**IN THE MATTER OF AN APPLICATION TO
AN BORD PLEANALA**

**For Approval of the Railway (Metrolink – Estuary to Charlemont via
Dublin Airport) Order [2022]**

ABP-314724-22

Schedule of Errata

## Legend

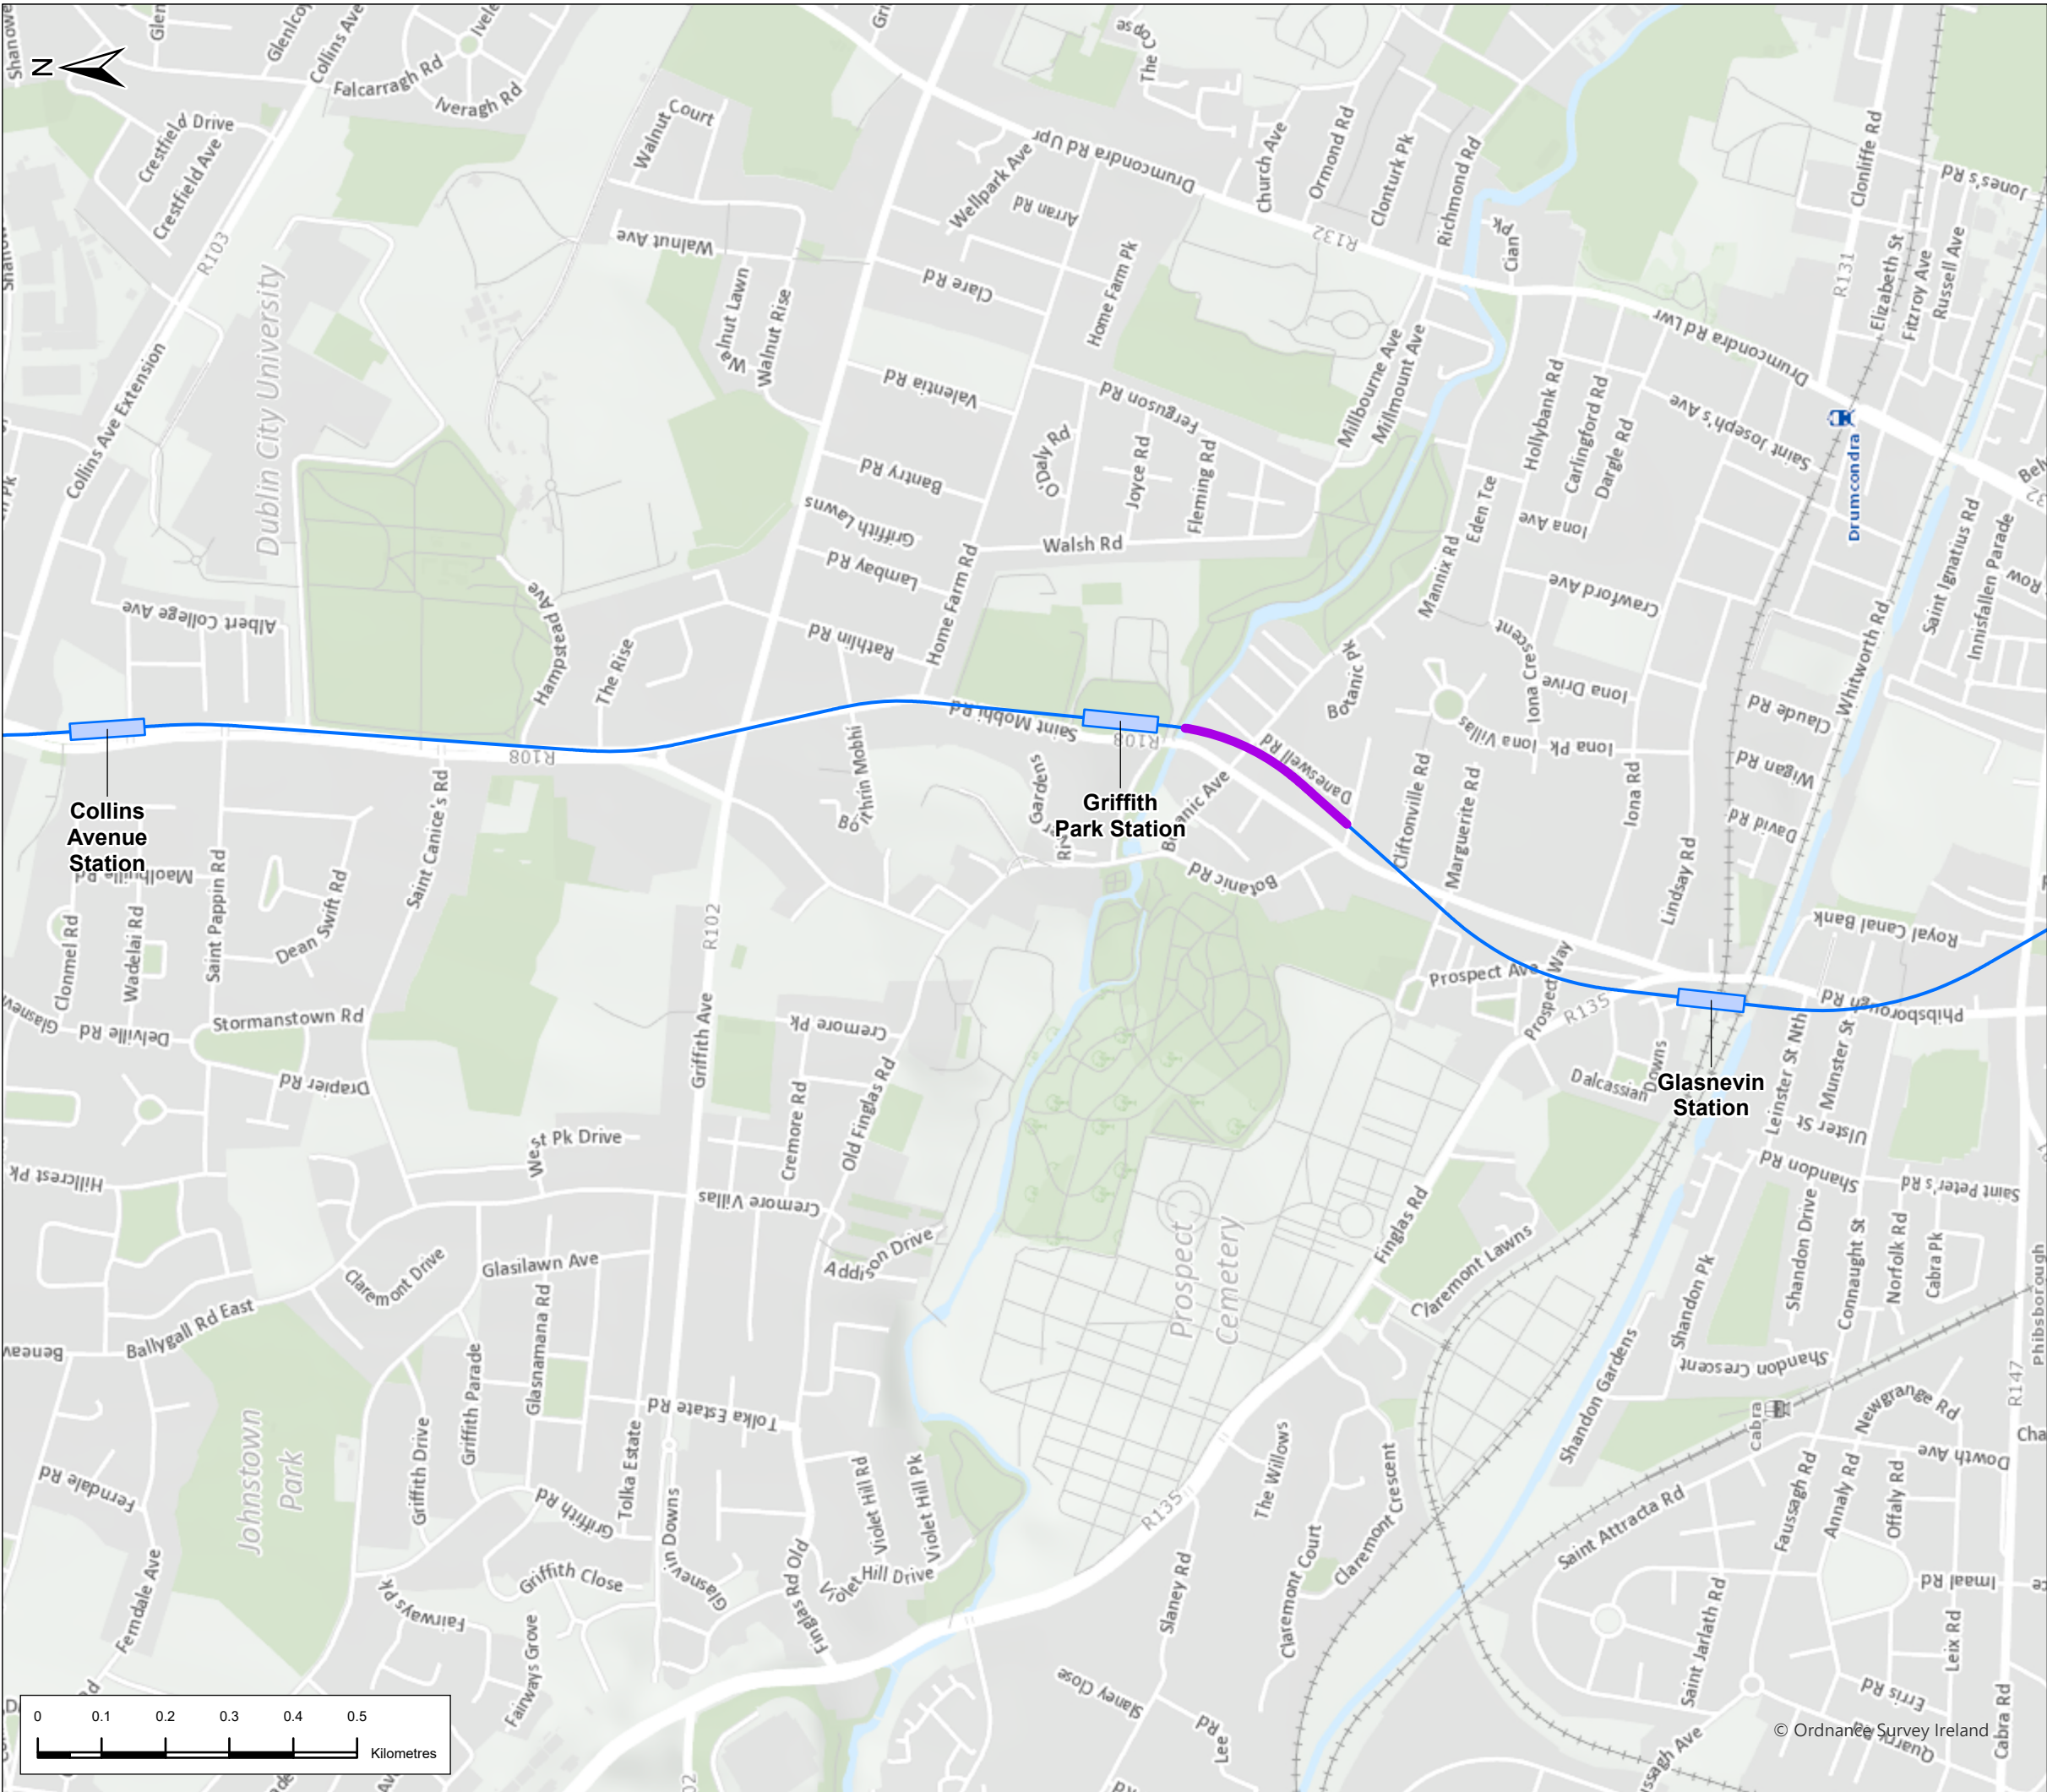
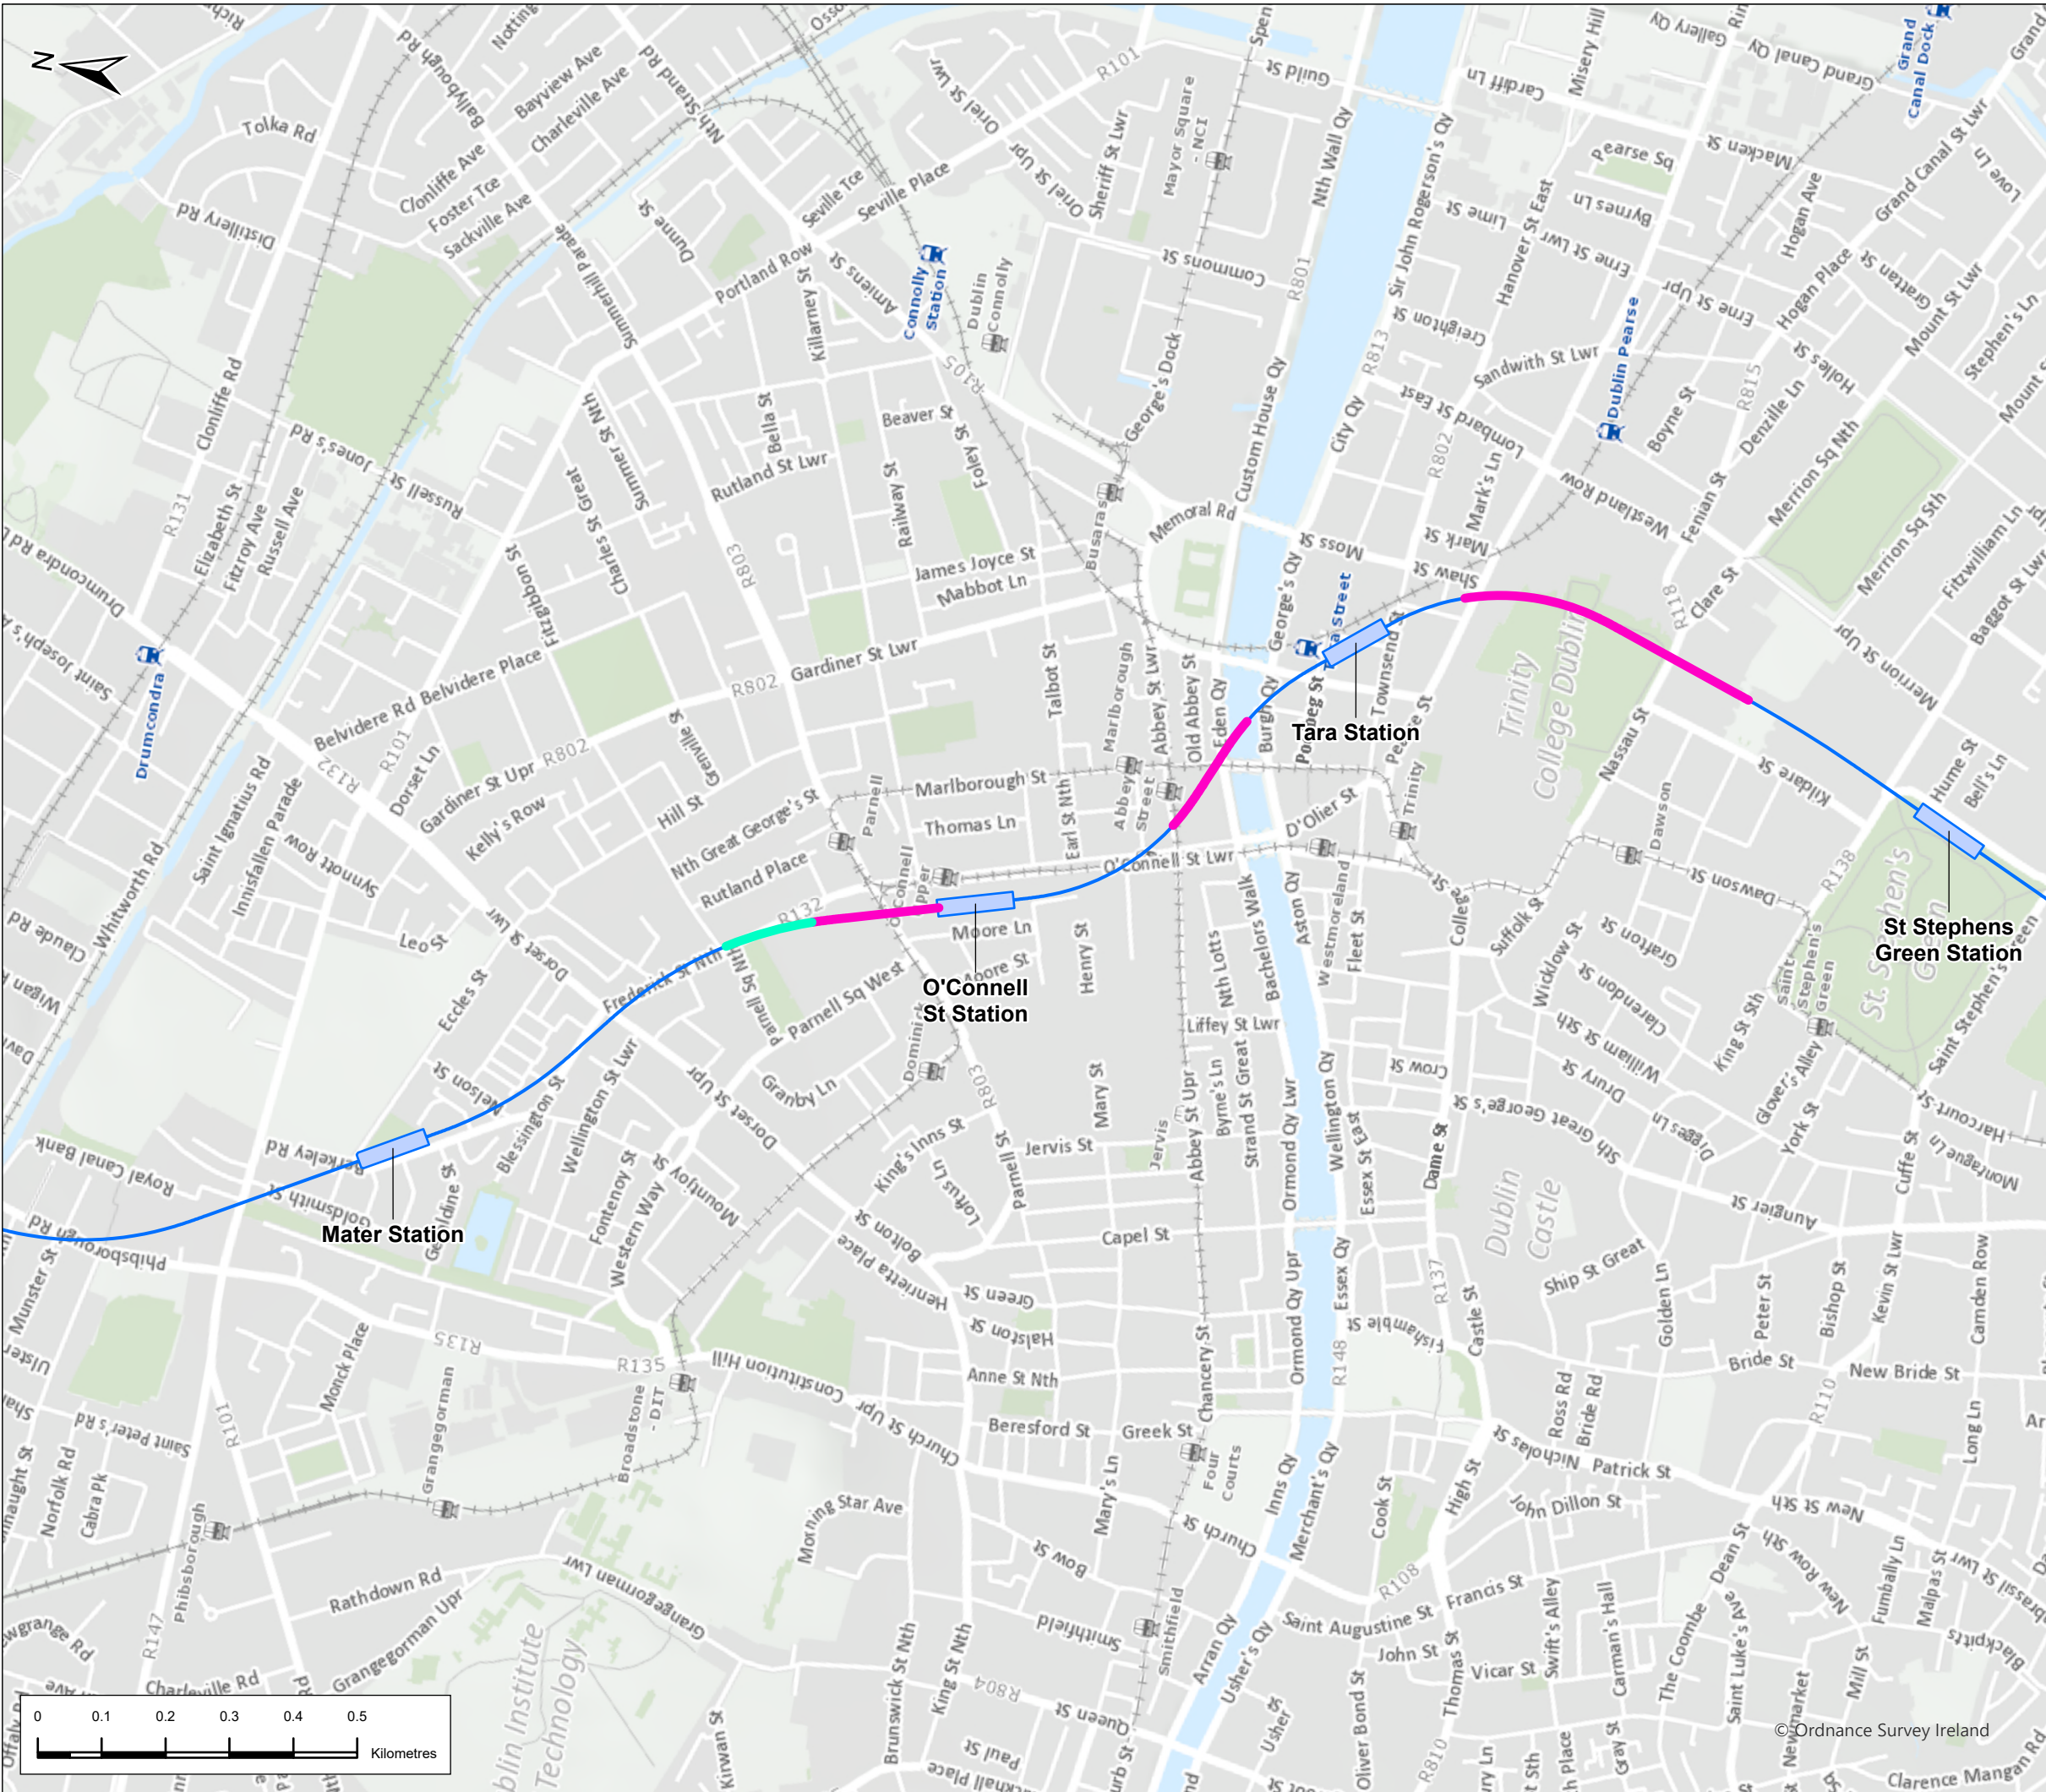
37.	EIAR Chapter 14 Groundborne Noise and Vibration	n/a	n/a	Additional Figure, showing proposed locations for Floating Slab Track	Additional Figure, showing proposed locations for Floating Slab Track. Please refer to Appendix 12 Updated and Additional GBNV Figures.
